Commitment Letter

Project Name: McGehee Subdivision

Description: McGehee Subdivision is proposed with two (2) residential lots on approximately 10.50 acres. The development is the replating of Lot 3 of Mountain Shadow Ranch Second Phase. This proposed subdivision is located east of Highway 83 and north of Hodgen Road in Section 19, Township 11 South, Range 65 West.

FINAL PLAT

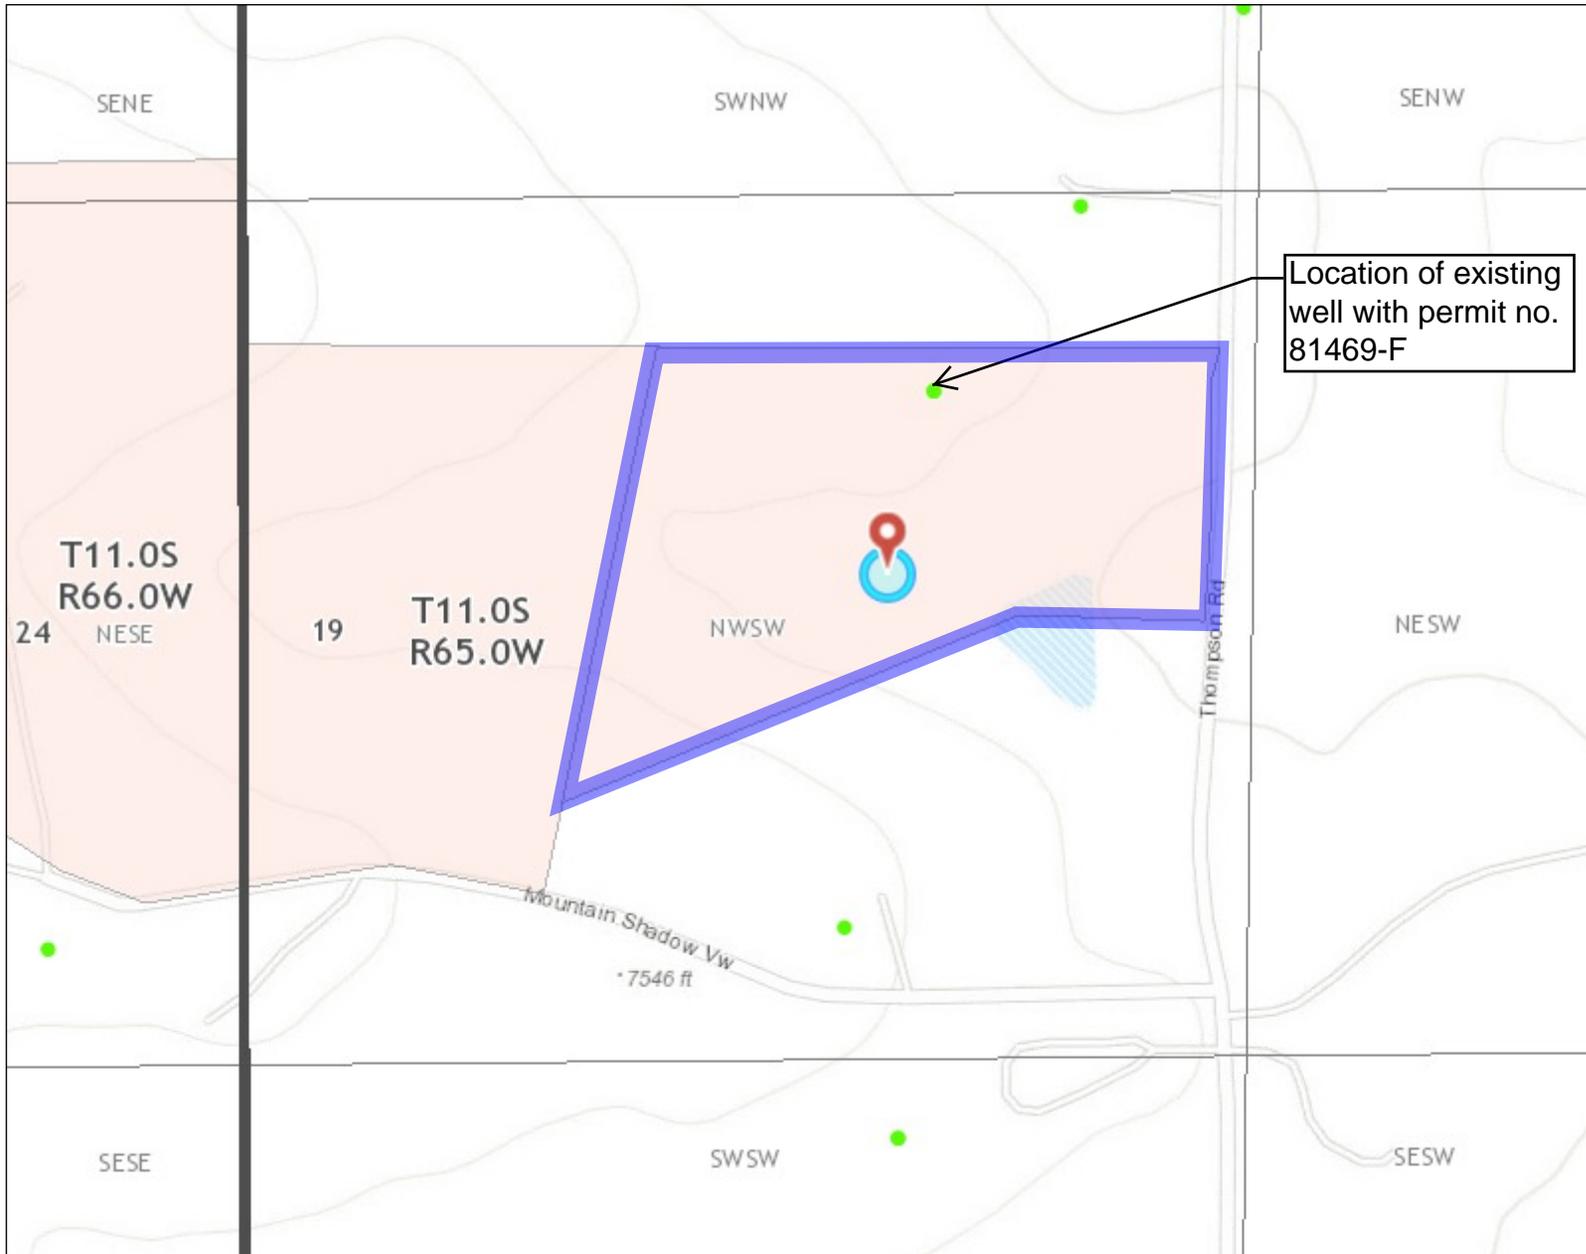
MVEA requests a five (5) foot both sides of the common side lot line utility easement along with a twenty (20) foot exterior utility easement on plat. MVEA also requests platting of existing MVEA facilities with easement on the plat. If open space, road right of ways, drainage and landscape tracts are designed in this subdivision MVEA requests these areas be listed to include utilities. Additional easements may be required once a review of civil drawings with grading and erosion plan is provided to MVEA.
